6 August 2022

National Trust objection relating to the Powerhouse Ultimo Renewal - State Significant Development (SSD-32927319)

Project No.	2138	Scale @ A2	1 : 500
	Date	SEPT 2022	Co-Ord	
	Dwnn	CT	Chck	MB
Drawing Status		FOR APPROVAL		
Drawing No.			Revision	
AR 0500			10

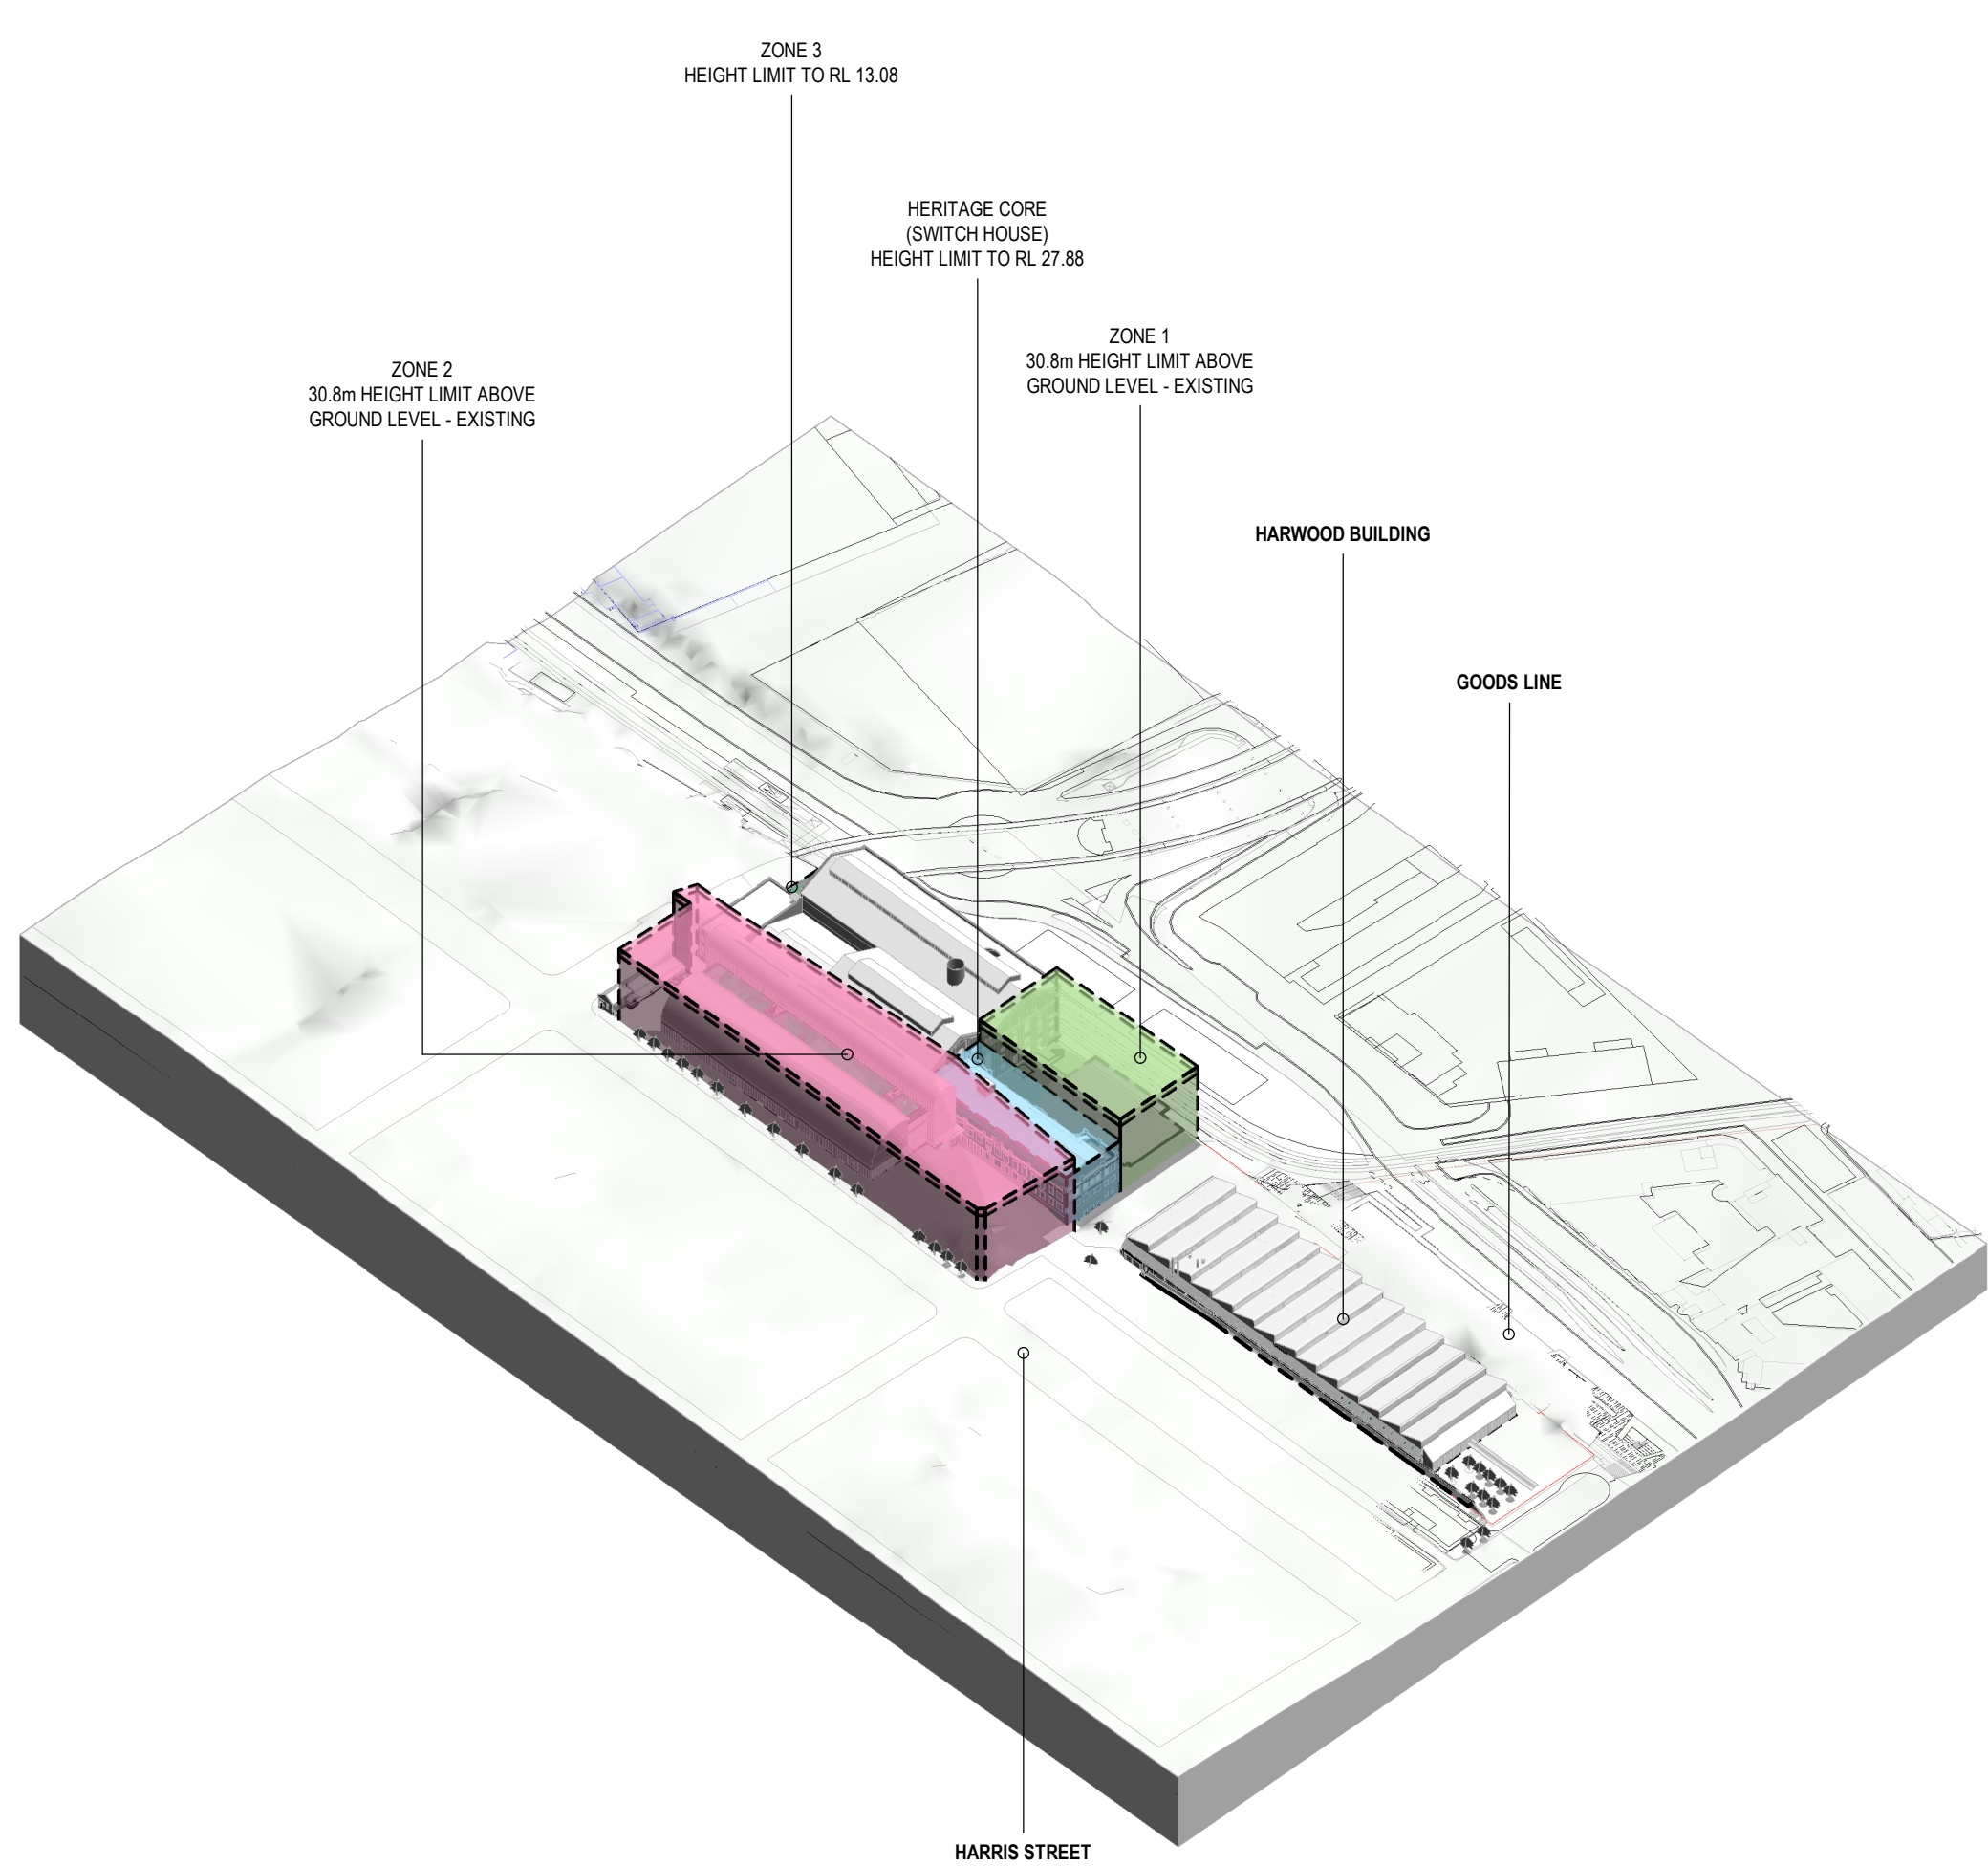
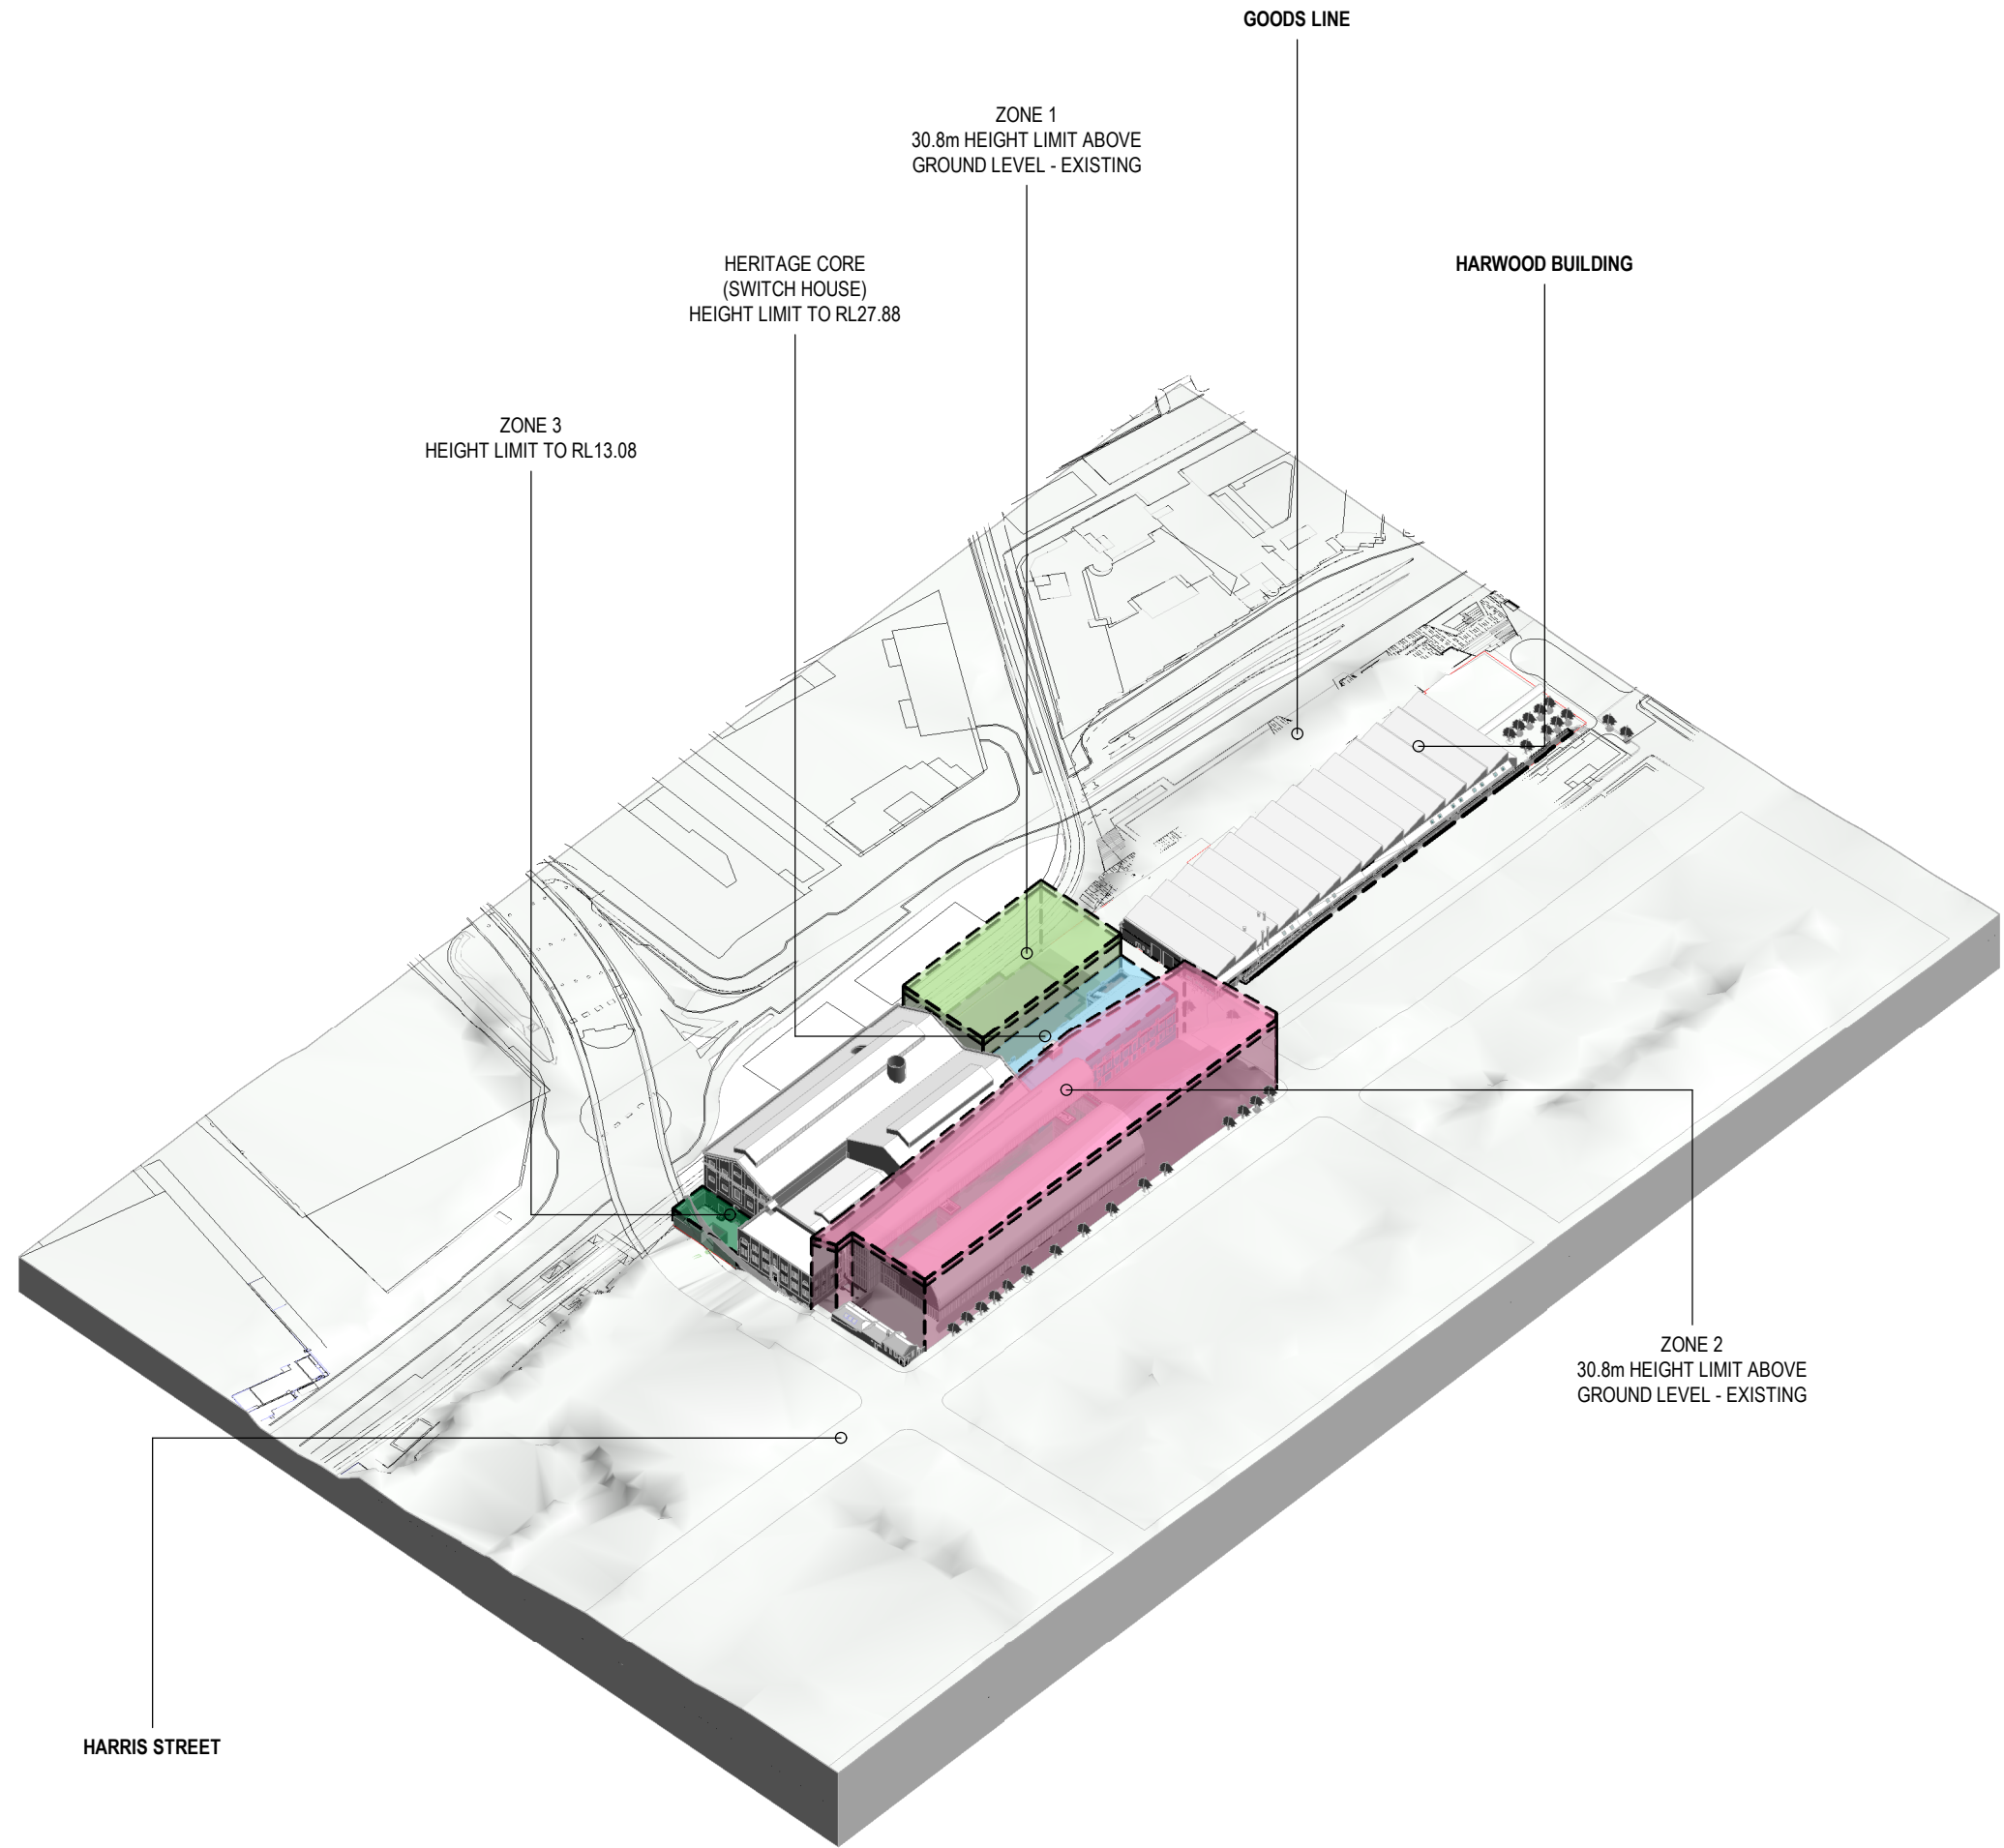
The Trust does not support the maximum building envelopes proposed in the application. An adequate assessment of the impact of proposed built form and urban design cannot be made based on the shaded ‘boxes’ placed over heritage buildings as currently exhibited.

It is unclear and unjustified as to why a “maximum building envelope” approach has been used. The exhibited documents clearly state that due significant heritage buildings, a maximum building envelope **would not be achievable** across the entire site. The question must then be asked why consent is sought for a blanket maximum building height envelope across the entire site?

The impact of the proposed additional built form above the heritage items is not adequately assessed or acknowledged. Such additional works would obscure the distinctive profiles and forms of heritage listed buildings of exceptional significance and deeply affect the legibility of their historic built forms and significant views.

The maximum building envelopes are not supported in any way. These should be immediately revised to create envelopes that are appropriate to the heritage structures and the wider site. The design brief should not include any additions at all above the original state-listed Power House components of the site.
